Application by Four Ashes Limited for an Order Granting Development Consent for the proposed West Midlands Interchange

Examination timetable – Deadline 3 submissions

Deadline 3: Comment on submissions for deadline 2

rev
Figure 12.4 **D**

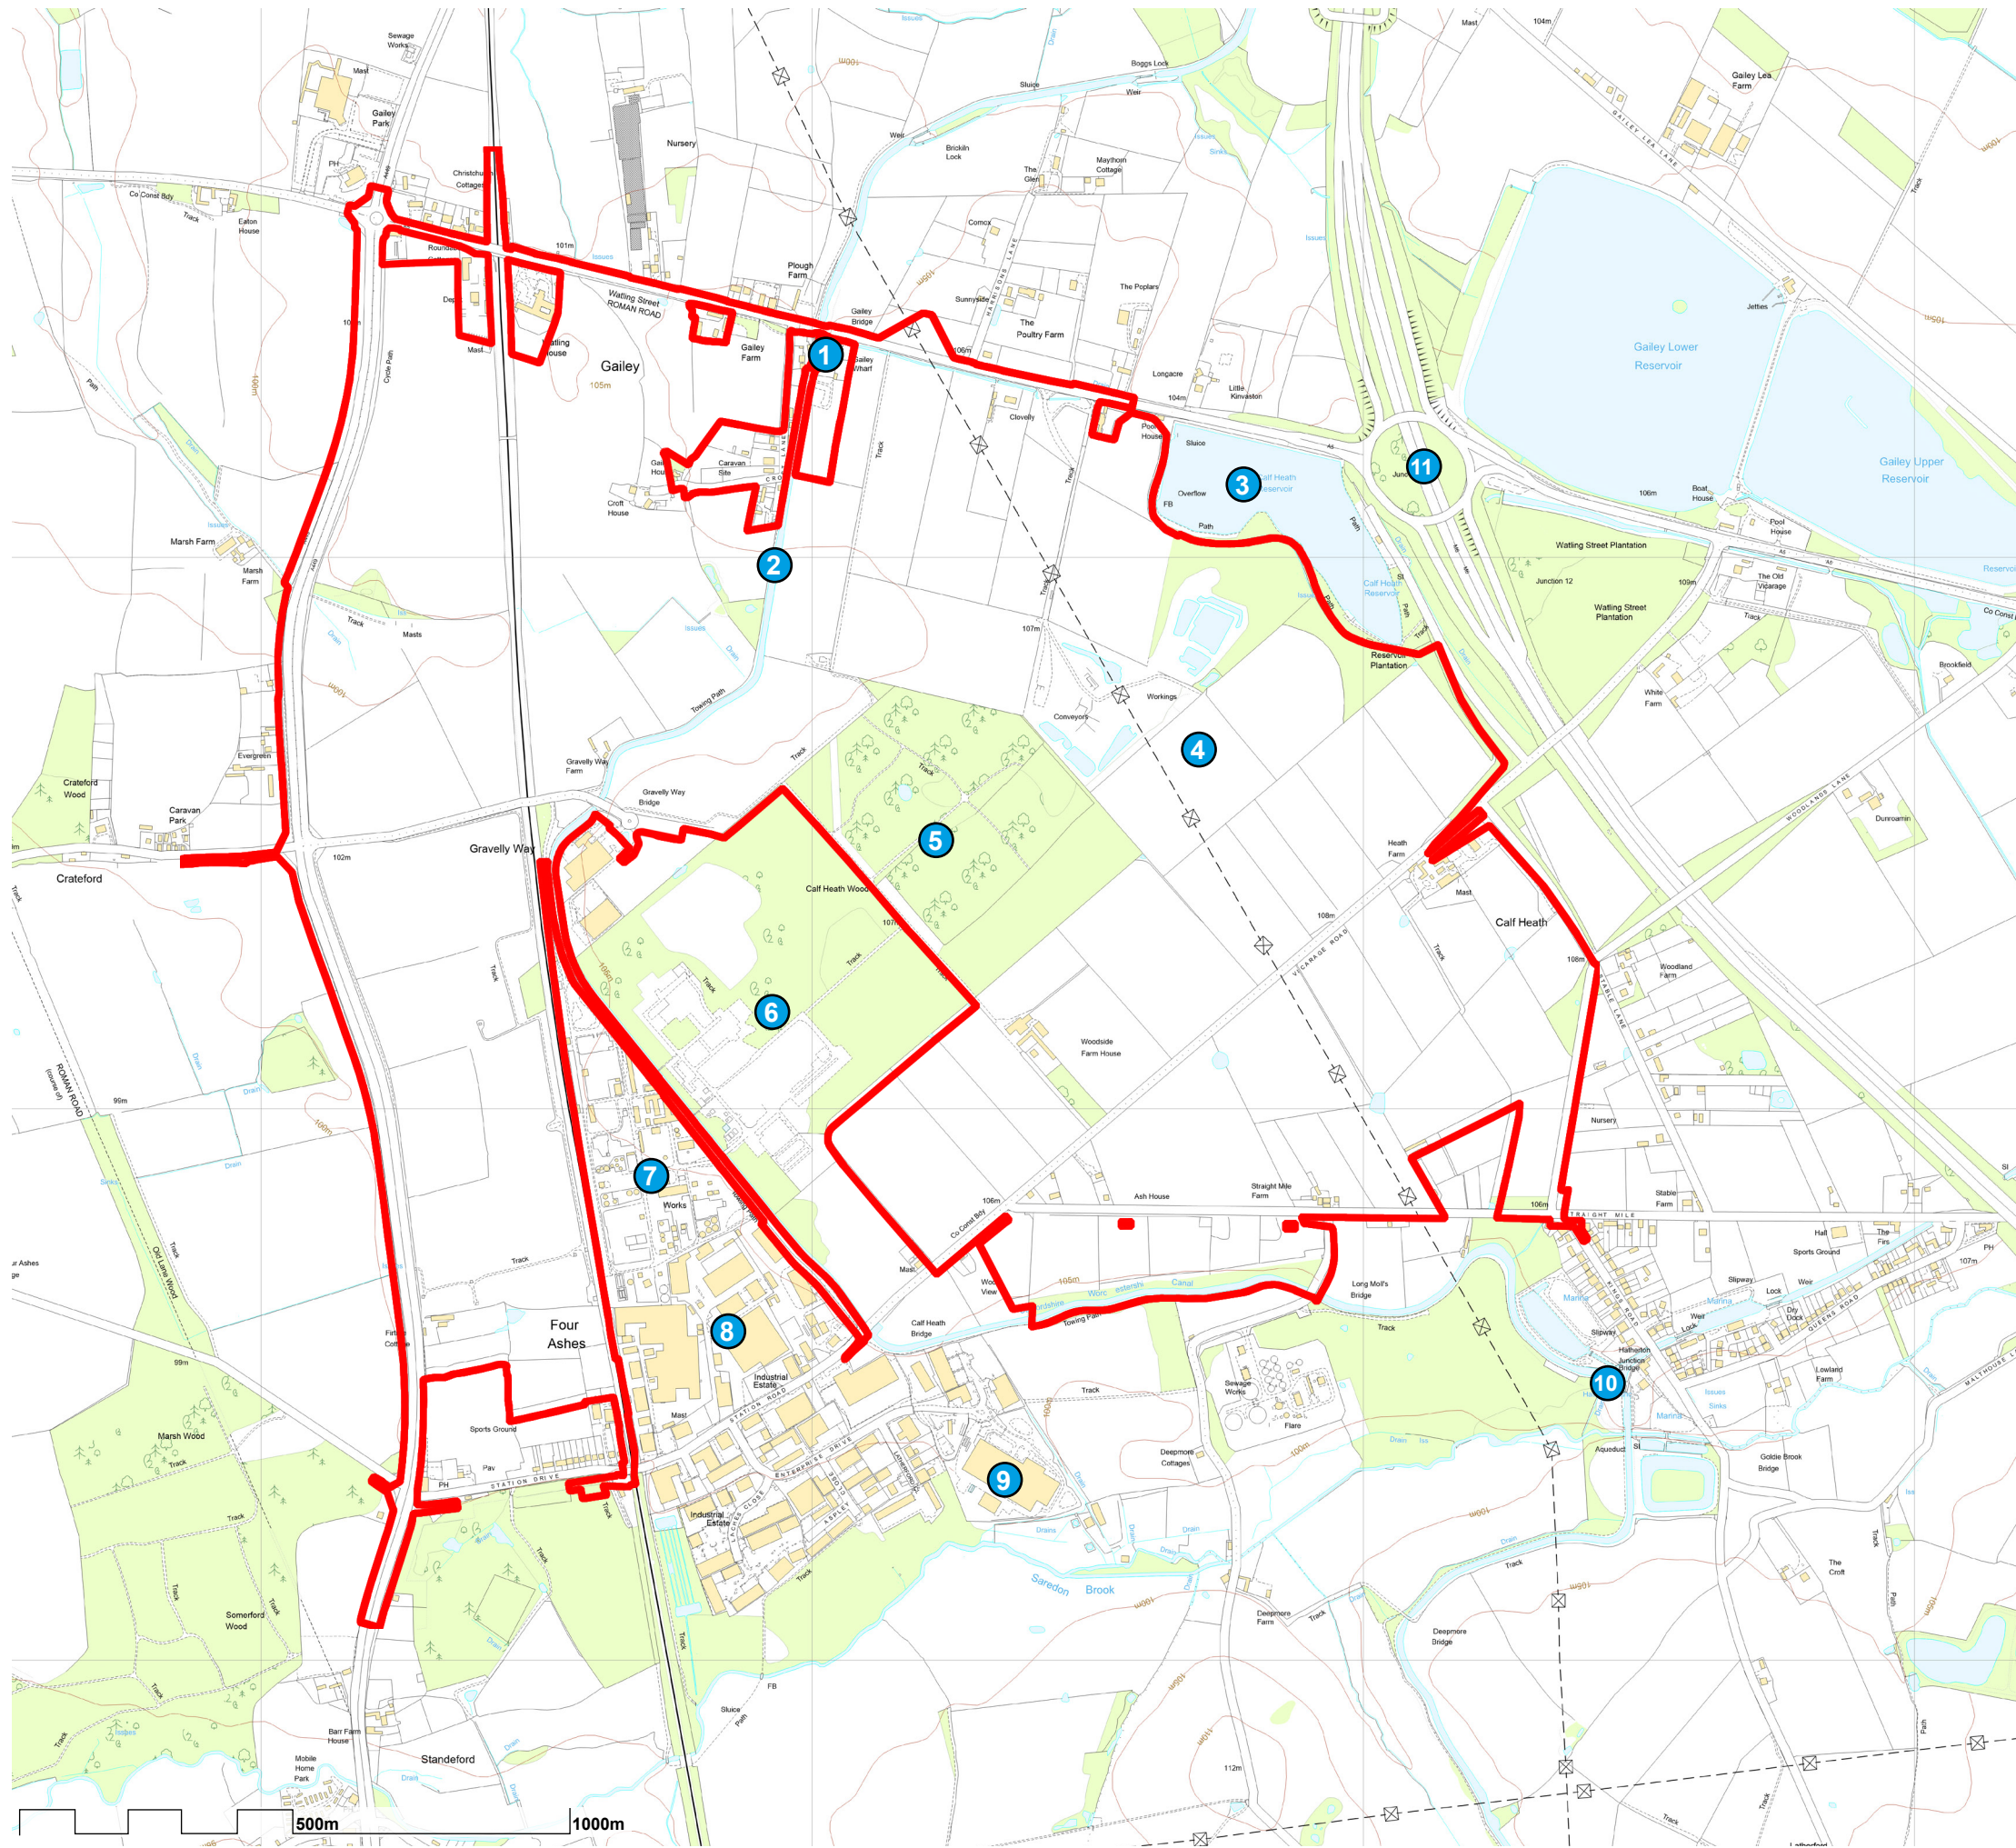
Whilst it is acknowledged that the site will impact a short section of the whole of the Staffordshire & Worcestershire canal it should be noted that the site sits between two important and busy locations on the canal: Gailey Wharf and the junction with the Hatherton Canal.

With regards to viewpoints along the canal the Trust wish to highlight that the canal and the conservation area designation extend eastwards beyond Long Molls Bridge. Views within Section A.3 may be restricted by landscaping within the proposed community park. However as demonstrated by Viewpoint 7 (ES Document 6.2 Chapter 12 Figure 12.13) open views from the canal, south of Straight Mile, to the site will remain.

The focus of the individual does not and is not solely concentrated on the direction of travel as it may be on a road or motorway. In any event the canal to the east of Long Molls Bridge meanders with users, particularly those travelling north, getting a direct view across to the site, as per Viewpoint 7.
